April 26, 2019

**RE: Tin Can Alley
6100 Alameda NE
Grading & Drainage Plan and Drainage Report
Engineer's Stamp Date: 04/22/19
Hydrology File: C18D086**

Based upon the information provided in your resubmittal received 04/22/2019, the Grading & Drainage Plan and Drainage Report **is not** approved for Building Permit. The following comments are based on a meeting with Larry Kennedy from your office on 04/25/2019 and markups which I provided to him:

1 | grading and drainage plan
c101 | 1"=20'

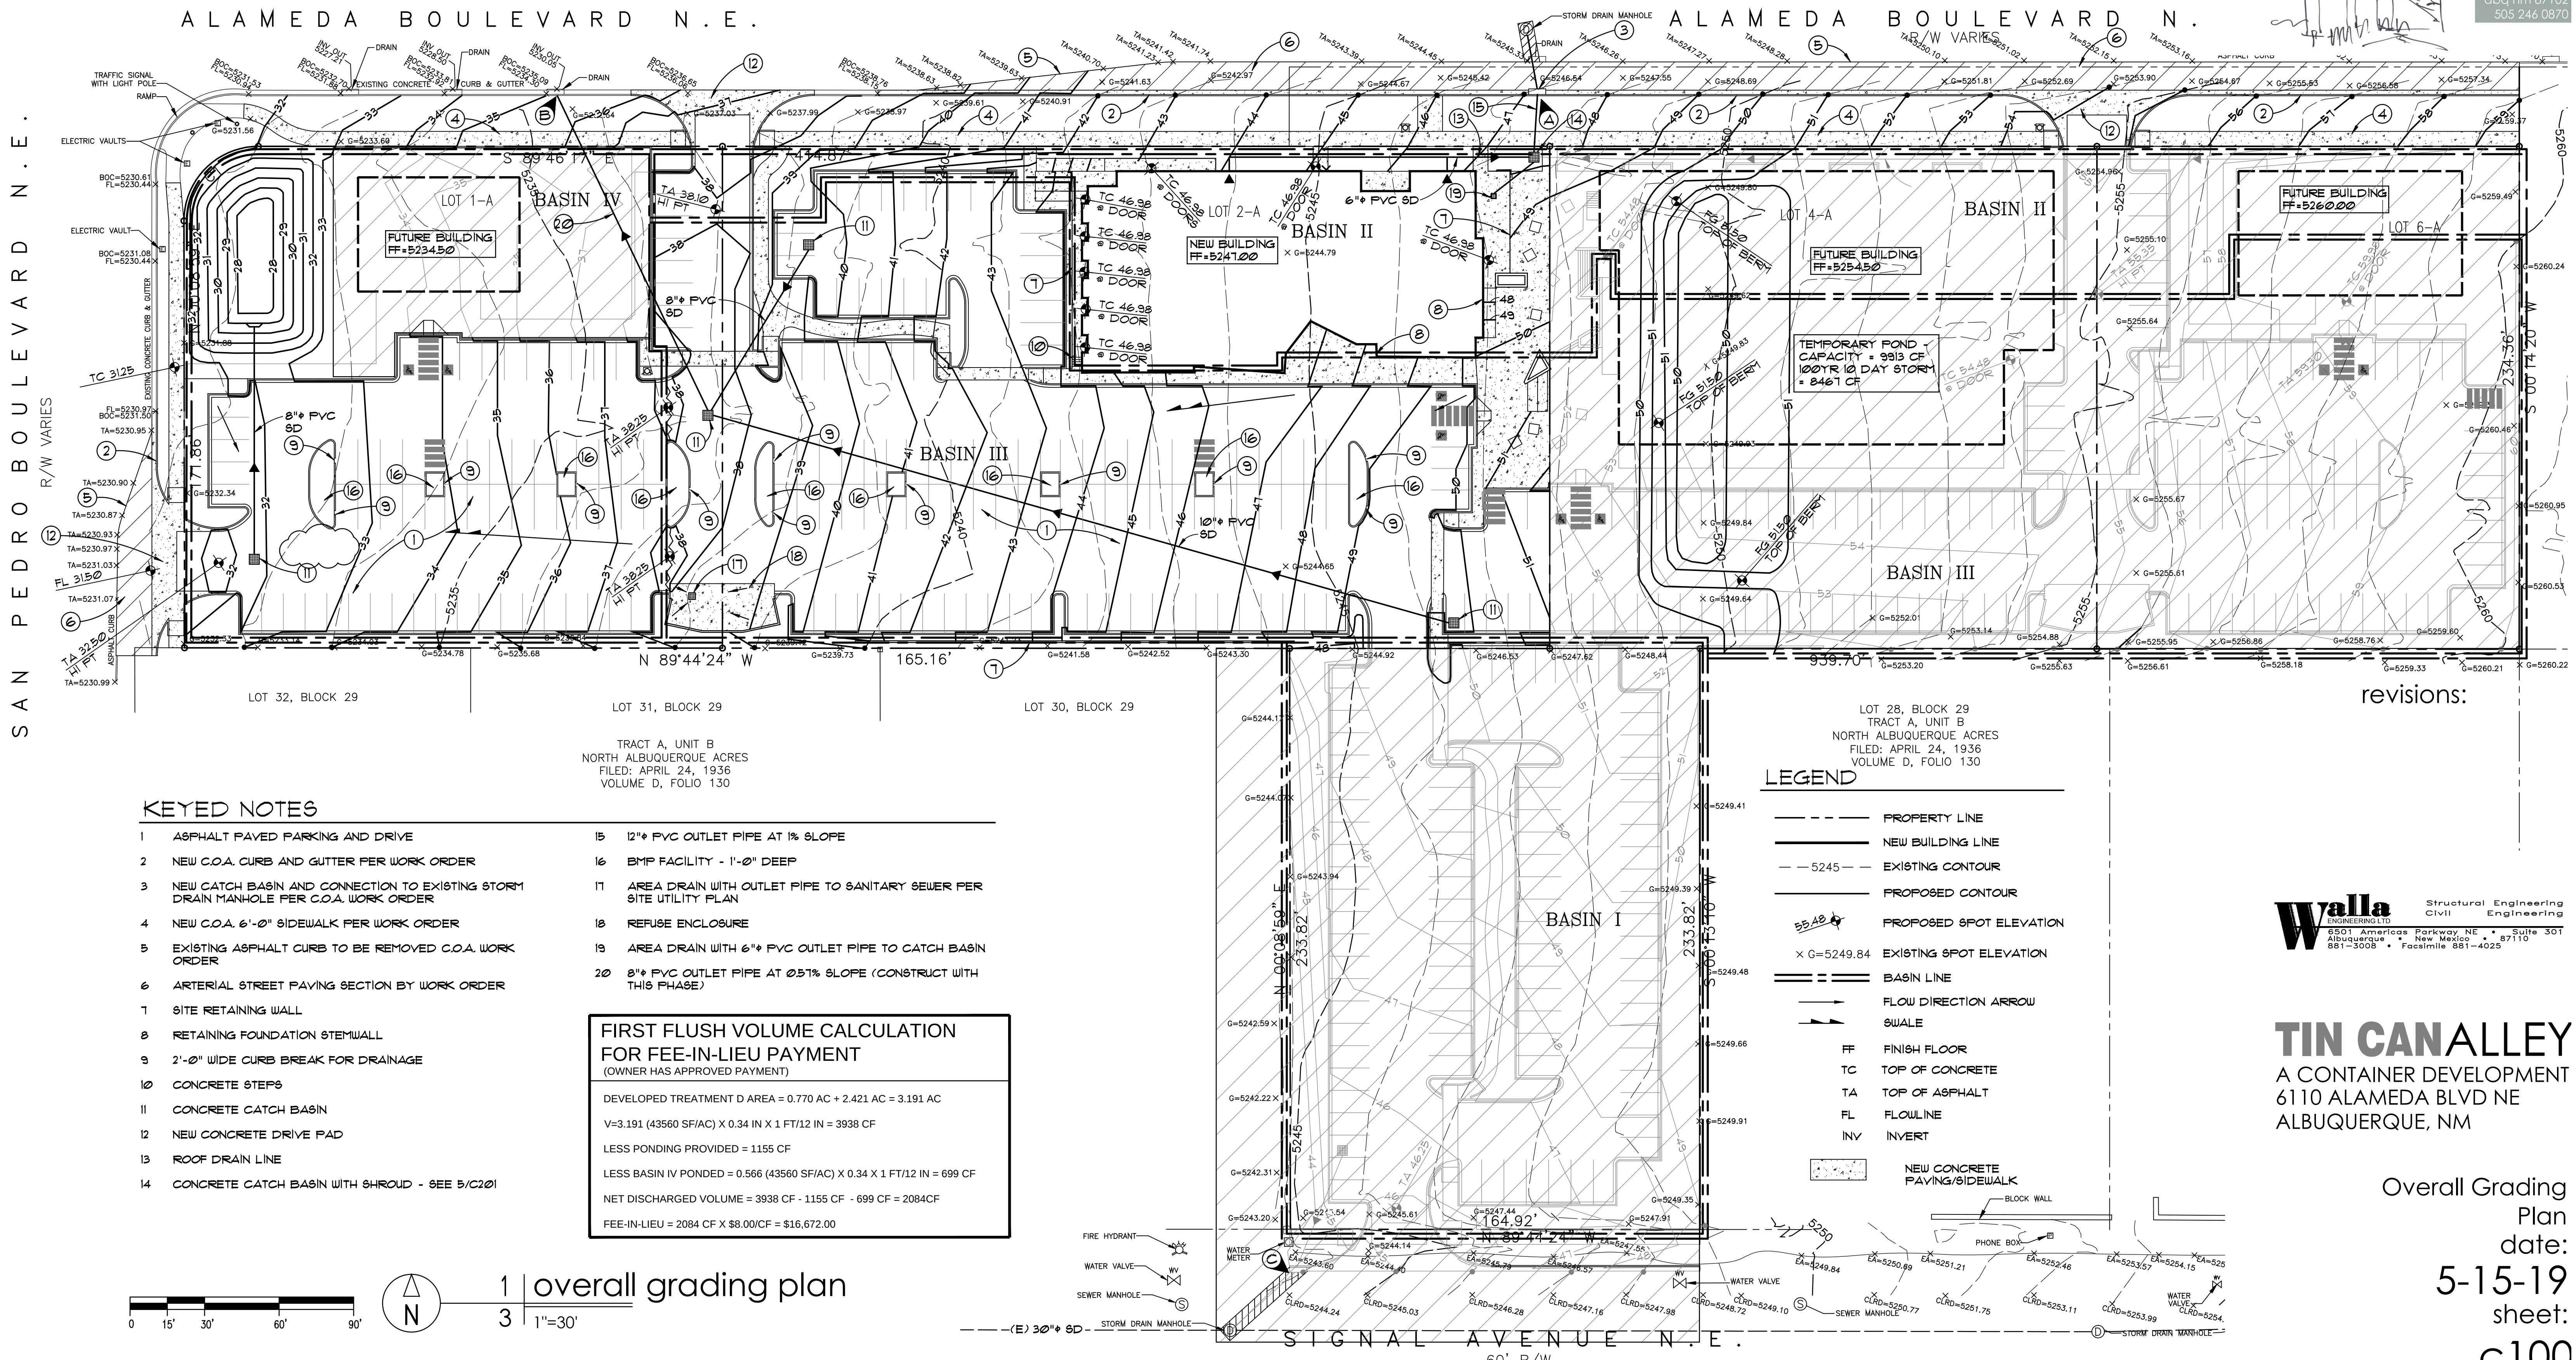
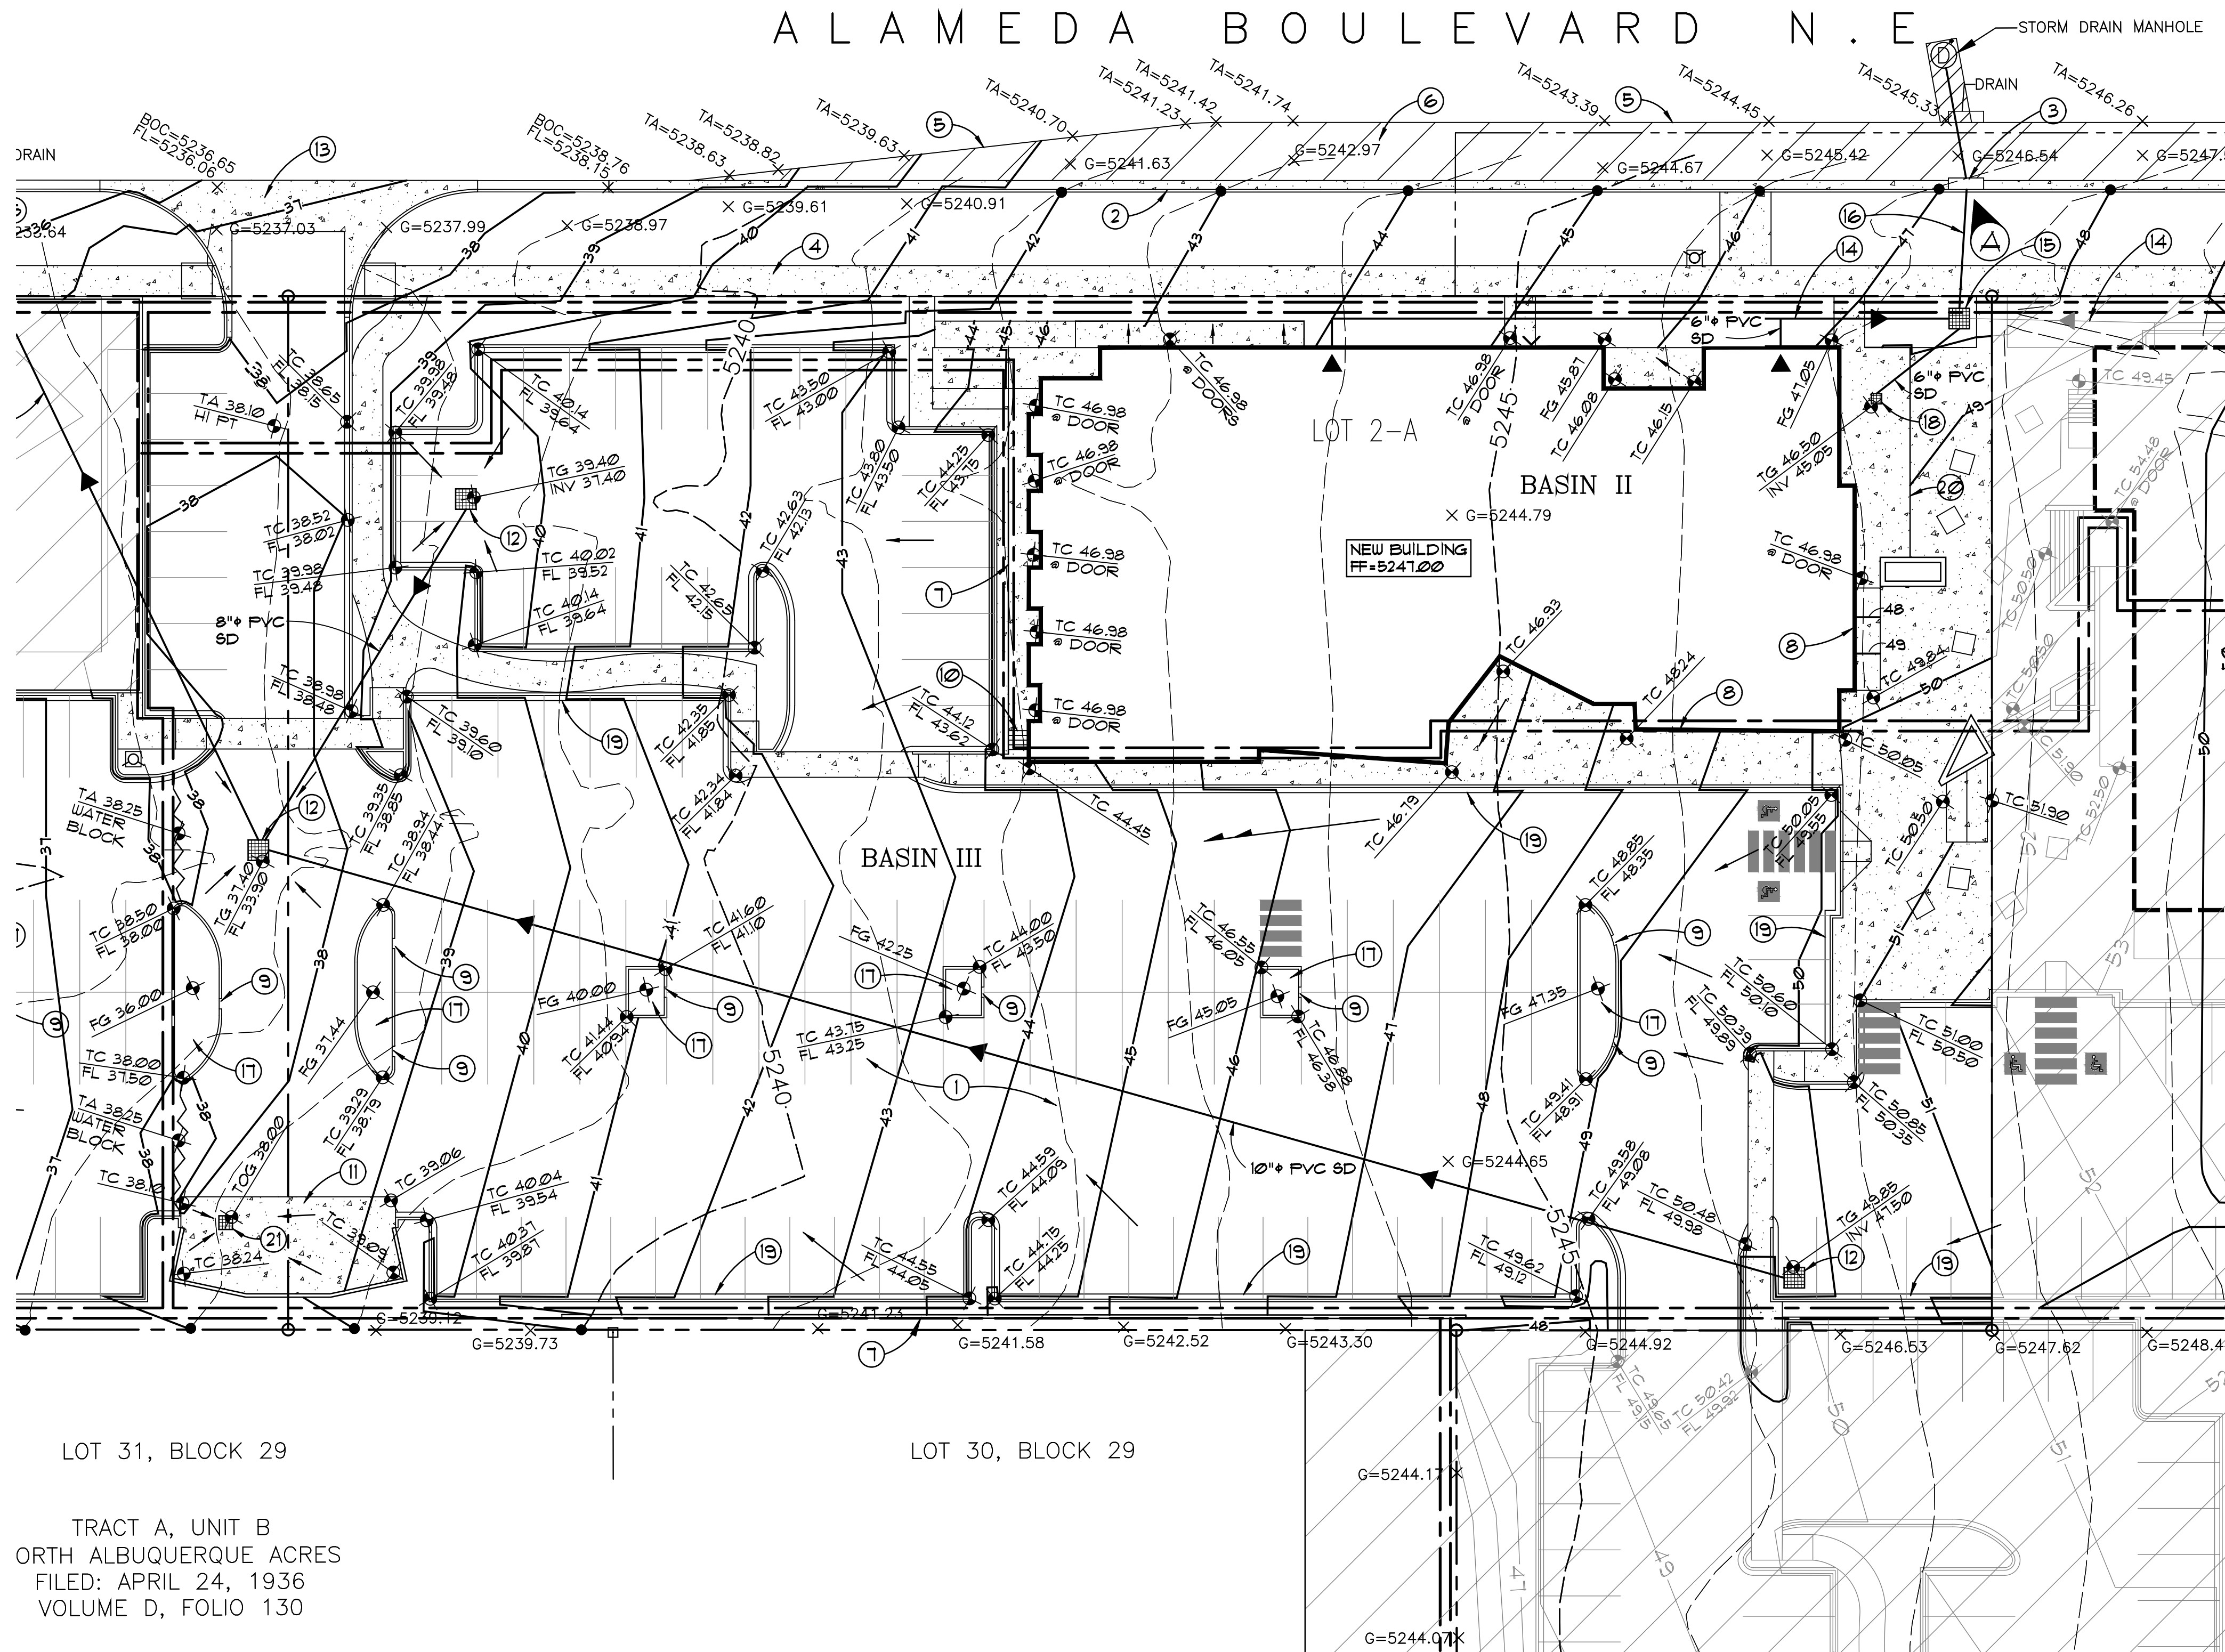
1. The HGL in the manhole in Alameda is 5231.1. Starting here and traveling through the proposed storm system, the HGL at the inlet (note 15) is 35.37 and rim of 35.75. This means that the proposed underground detention and all downstream storm sewer will not be able to discharge into the storm system and will easily go over the waterblock of 32.50 at San Pedro. Therefore, we propose two solutions.

- a. Do a complete study for the installation of inlet(s) on San Pedro along with the upsizing of the existing 48-inch pipe to probably a 60-inch and a manhole. This infrastructure will have to go back to the DRB for a revised Infrastructure List approval. This option seems to be costly and more time consuming so I suggest the second option.

- b. This option eliminates the underground detention facility and installs instead a retention pond along San Pedro for the ultimate development. The total allowable discharge to Alameda is $3.82 \text{ cfs/ac} \times 4.345 \text{ ac} = 16.59 \text{ cfs}$. Basin II is free discharge of 4.37 cfs and a remainder allowable discharge of 12.22 cfs. Basin III & IV have a 100 yr – 6 hr runoff of 15.9 cfs. 15.9 minus 12.2 leaves 3.7 cfs for retention. We will allow for the 100 yr – 6 hr volume to be used instead of the 10 day. So using the DPM, the area for retention is $3.7 \text{ cfs} / 4.49 \text{ cfs/ac} = 0.82 \text{ ac}$. The volume of retention is therefore $2.58''$ (excess type D) $\times 0.82 \text{ ac} = 7,717 \text{ cf}$. Therefore a pond $20' \times 80' \times 5'$ (depth) will provide a volume of 8,000 cf. This

pond will be walled with a security fence around it so no one falls in. A waterblock will need to be created at the curb return just to the east of the proposed underground detention. (Location provided on plans) Basin III will stop at this waterblock and Basin IV will extend to the south. Not only does the underground detention facility be eliminated, but two additional inlets and pipes are eliminated as well. (Marked on the plans) The inlet just to the east of the new waterblock, needs to be lowered a bit. This maybe lowered to say TG 37.50. (Please check to ensure that this is enough so that the runoff does not just go over the new waterblock) From this inlet, the outflow pipe can then connect to the most easterly of the existing three inlets. This pipe should be able to discharge the allowable 12.22 cfs. The only other new pipe is from the inlet by the San Pedro entrance and goes to the retention pond. This option also has the benefit of lowering the elected Payment-in-Lieu amount. Please verify the correct amount. By my calculation, for 0.82 ac @ 90% impervious will need a stormwater quality volume of 910 cf. Since this will be handled within the required retention pond volume it can be subtracted from the site's deficit volume amount. The total site stormwater quality volume is 3655 cf – 1155 cf (provided) – 910 cf (retention pond) = 1,590 cf. The Payment-in-Lieu amount is 1590 cf * \$8/cf = \$12,720. This is a savings of \$7,280. Along with the savings of the revised storm sewer system, this is a better option than the first one.

2. Please reflect the Grading and Drainage Plans for whichever option that you chose.
3. Please reflect the Drainage Report for whichever option that you chose.
4. Please add the calculations for the temporary retention pond to the Drainage Report.
